Our ref: Marsden Park Data Centre (SSD-70889211)

Subject: Additional Matters for Submissions Report (SSD-70889211)

The Department's comments on the Environmental Impact Statement (EIS)

DEVELOPMENT 1 - MP1.S2
CHILLER DECK

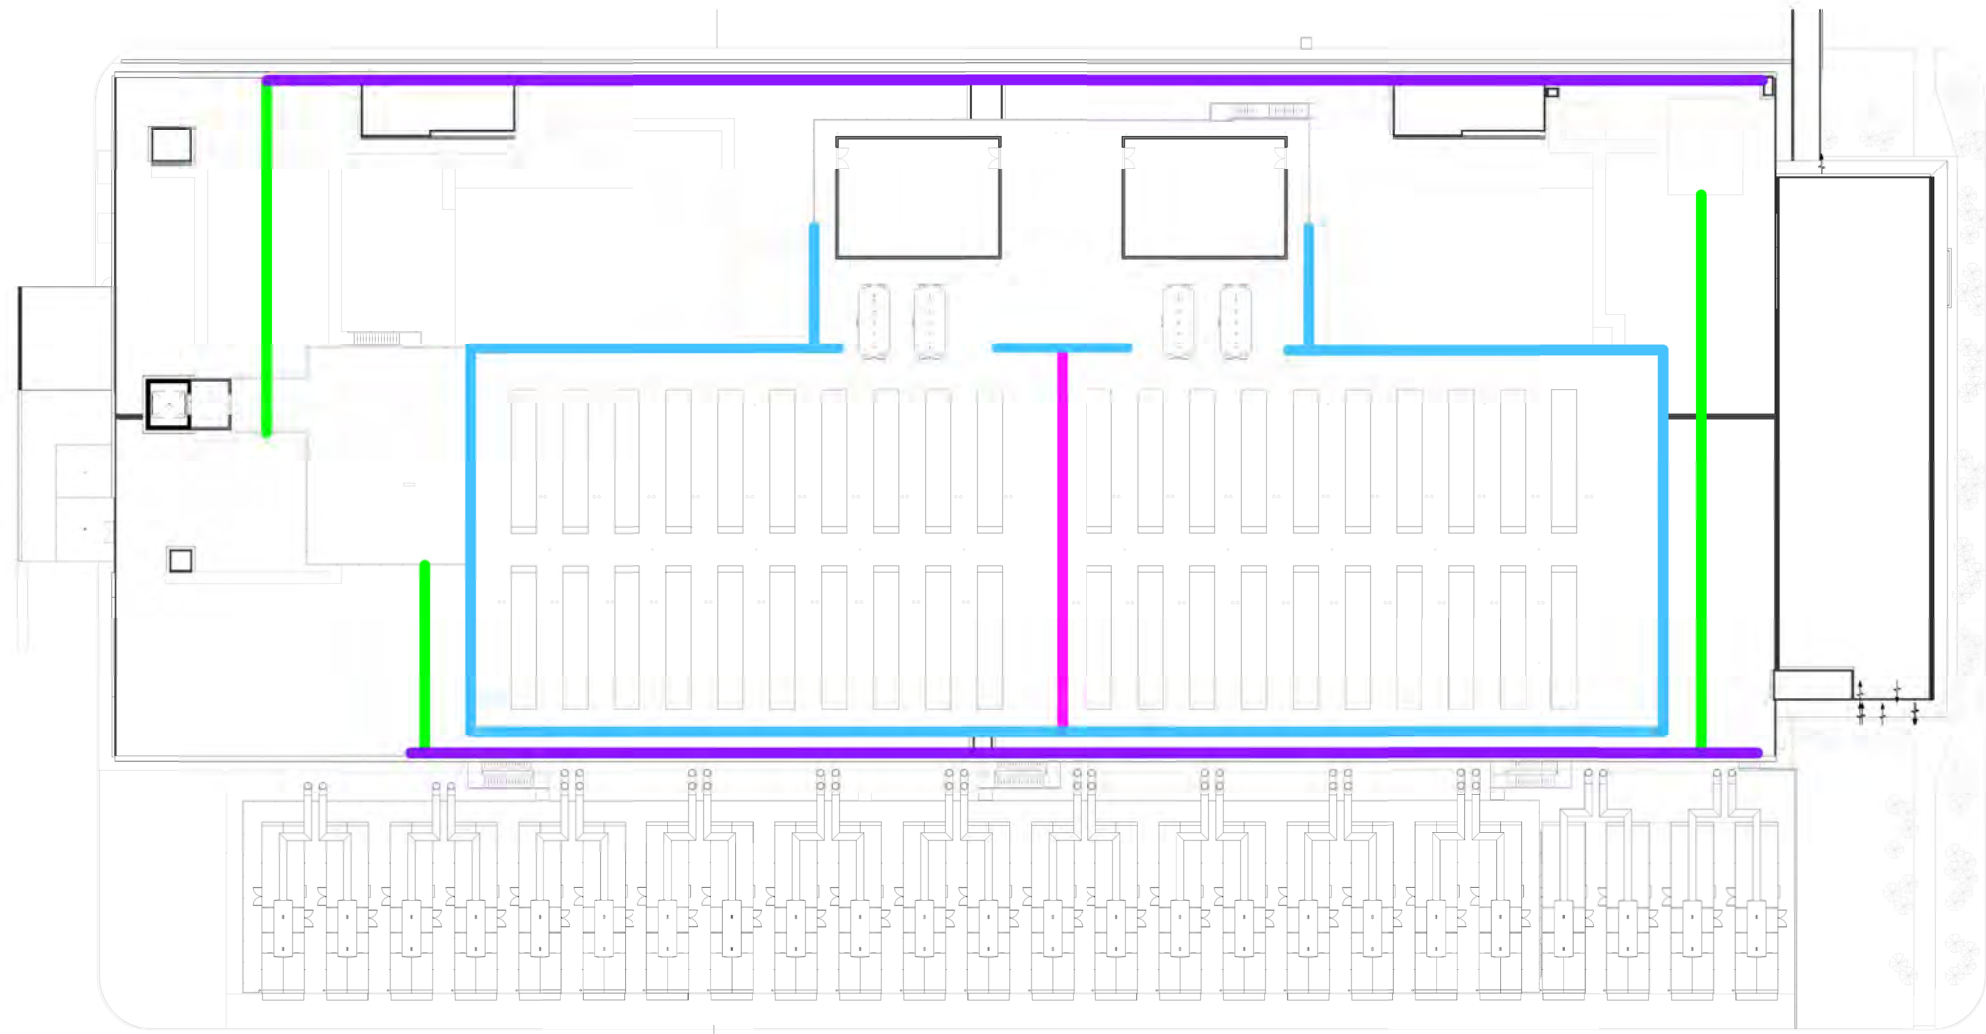
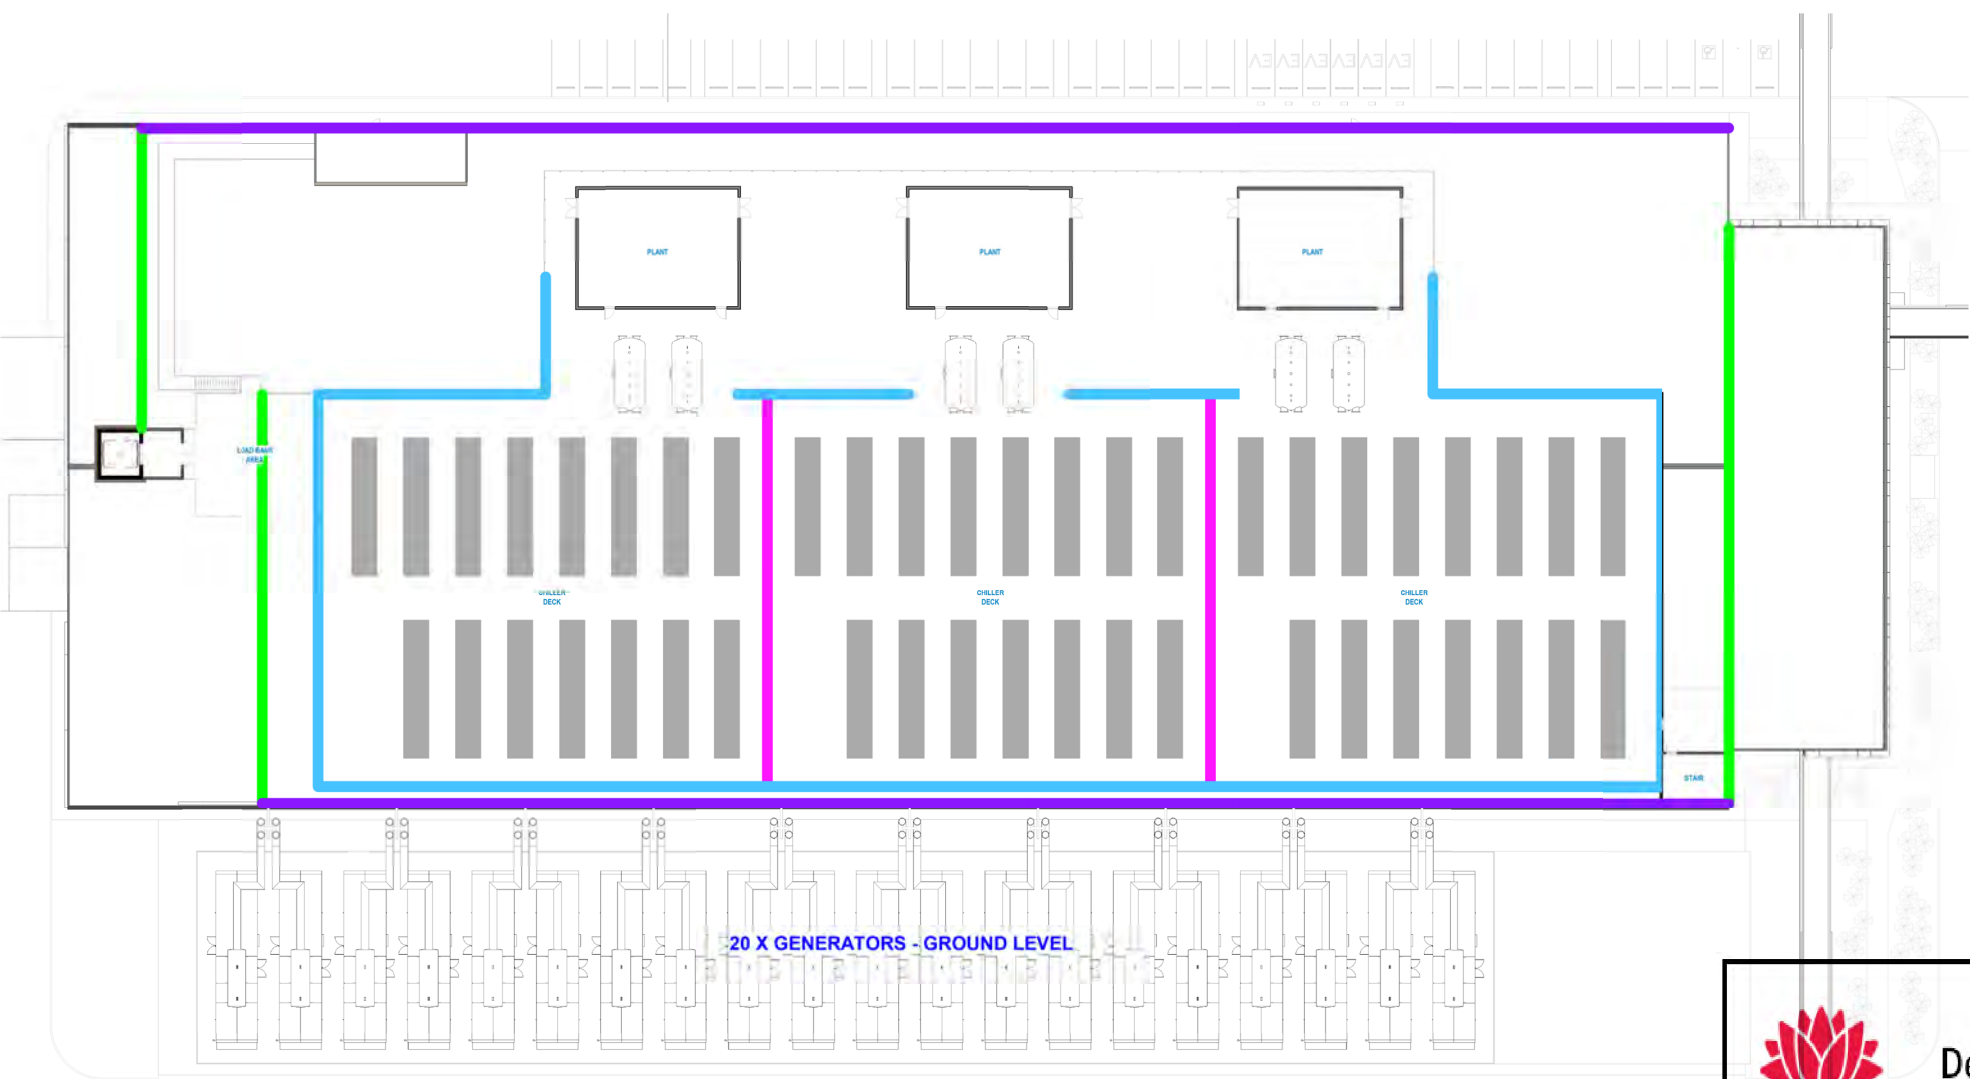
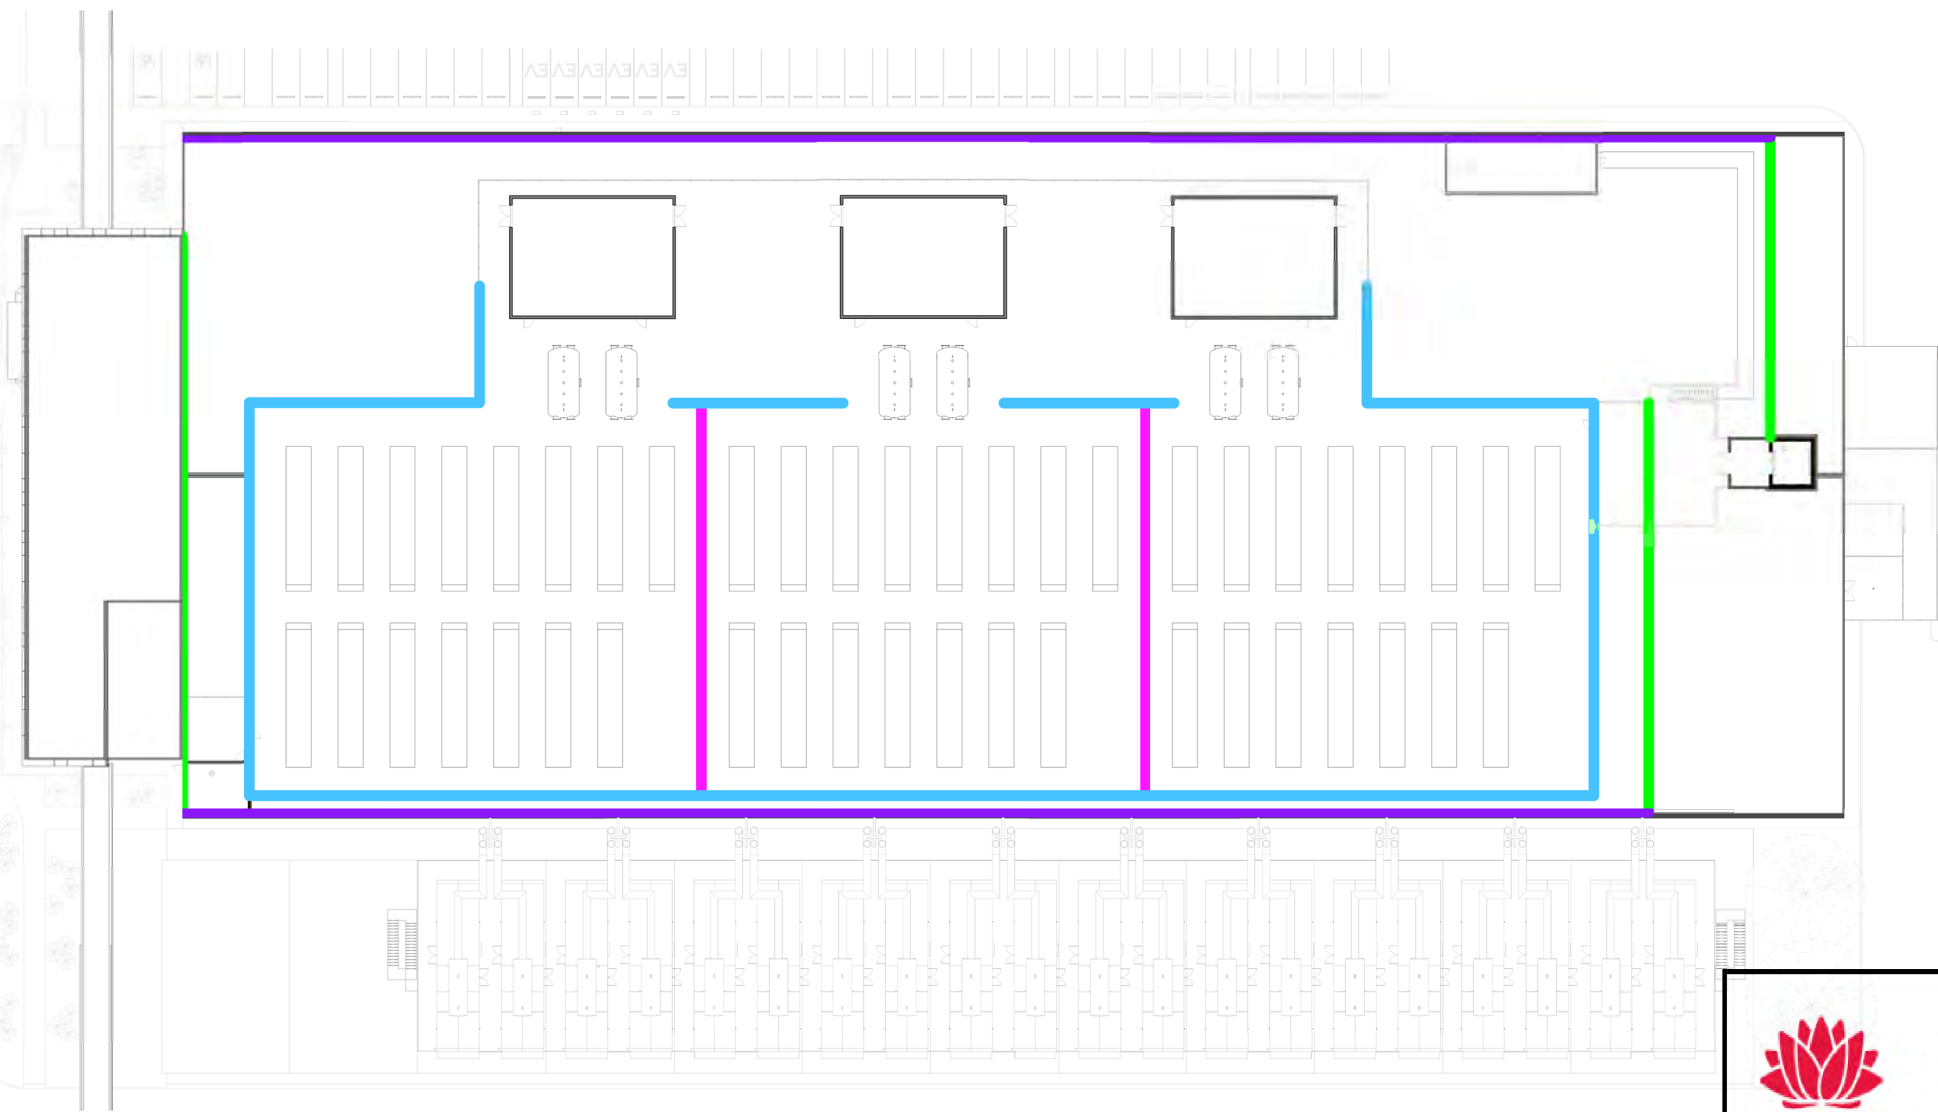
28. Given the proposed acoustic barrier treatments differ across each building, please provide detailed architectural plans for each of the six data centre buildings proposed under the subject SSD application.
29. The Department has concerns regarding the design of the development’s southern and eastern façades, particularly when viewed from residences to the south of the site.
